DECISION DELEGATED TO HEAD OF PLANNING

Application No: H06-0580-22 **Applicant:** Mr C Plumb

Proposal: Conversion of barn into pair of semi-detached dwellings - approved under H06-0189-20. Amendments to windows

Location: Granite House Chapelgate Gedney

Proposed East Elevation
Scale 1:100

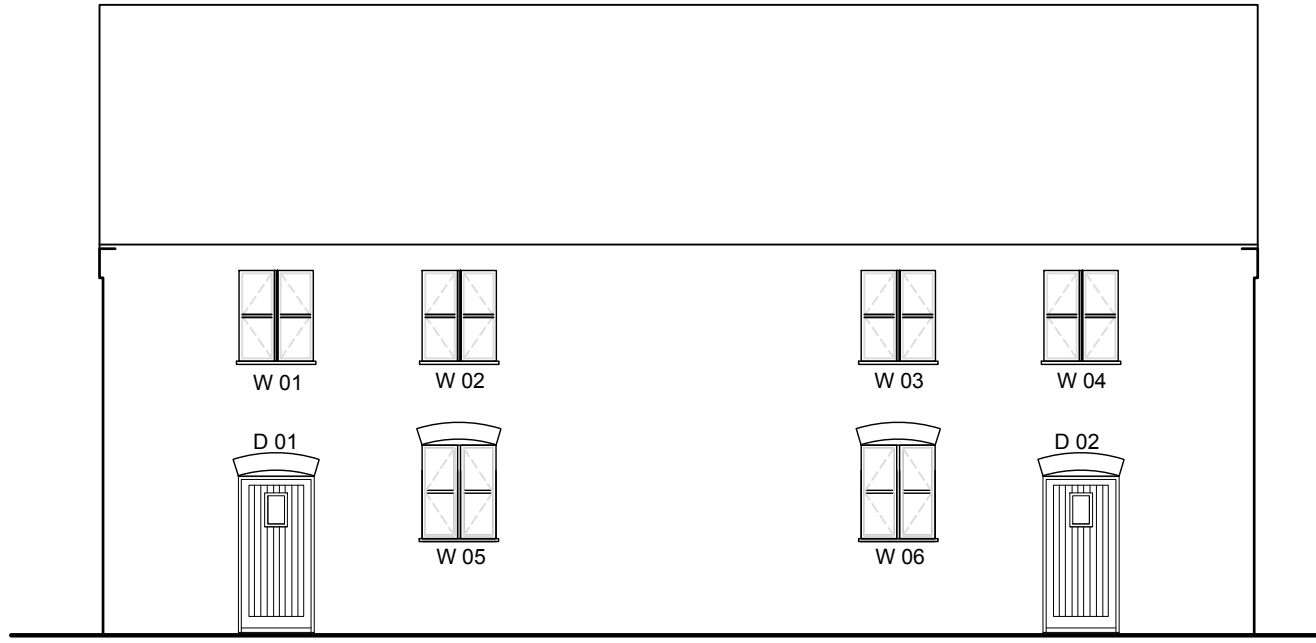
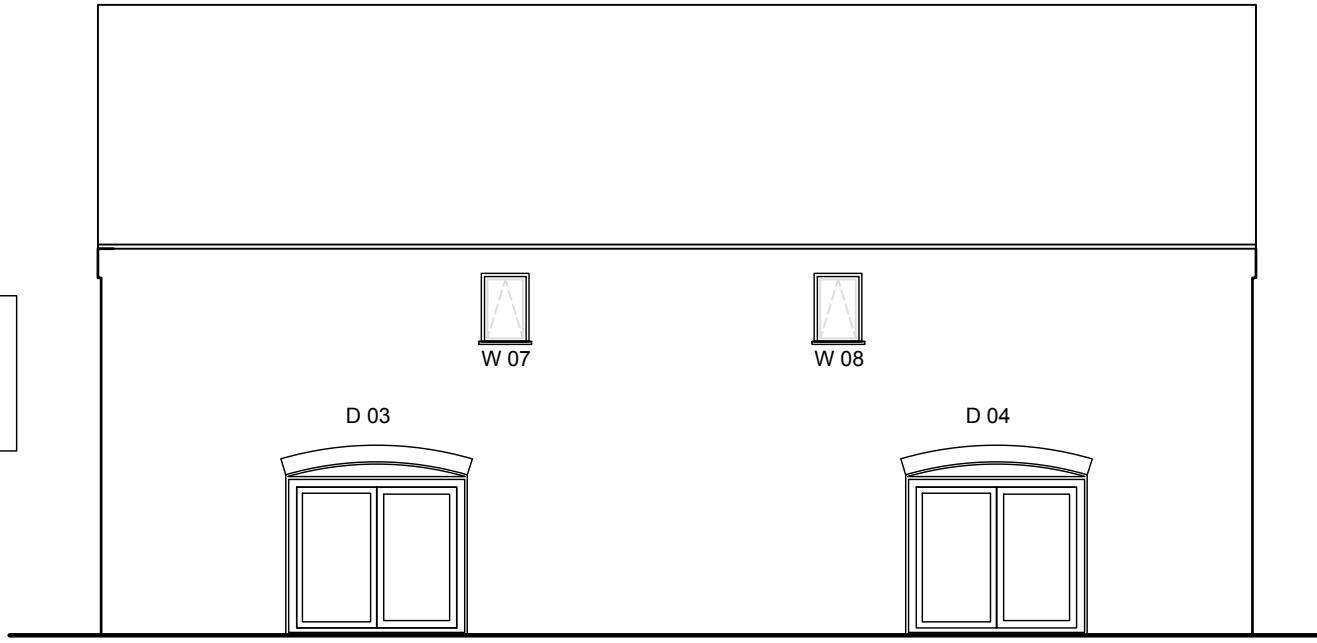
The site has full planning permission for the conversion of a barn into a pair of semi-detached dwellings (ref. H06-0189-20). This application is to increase the depth of the first floor windows on the northern, eastern and southern elevations from 900mm to 1200mm. The width would remain at 900mm. The windows on the western elevation facing no. 5 Whiteacre Gardens would remain unaltered. The reason for the alterations is to comply with means of escape under the Building Regulations.

1. No alterations are proposed to the site boundary;
2. The proposed alterations are minor and would not conflict with the South East Lincolnshire Local Plan, 2019;
3. No concerns were raised by third parties concerning overlooking of neighbouring property from the windows on the northern, eastern and southern elevations;
4. No specific conditions were imposed in relation to the windows the subject of this application;
5. The footprint would not be moved and the proposal would not have a material impact upon a neighbouring property;
6. The height of the building would not be increased;
7. The amendment would not result in overlooking of any neighbouring property to a greater degree than at present;
8. The alterations wouldn't fundamentally alter the design concept of the development;
9. No Environmental Statement was submitted.
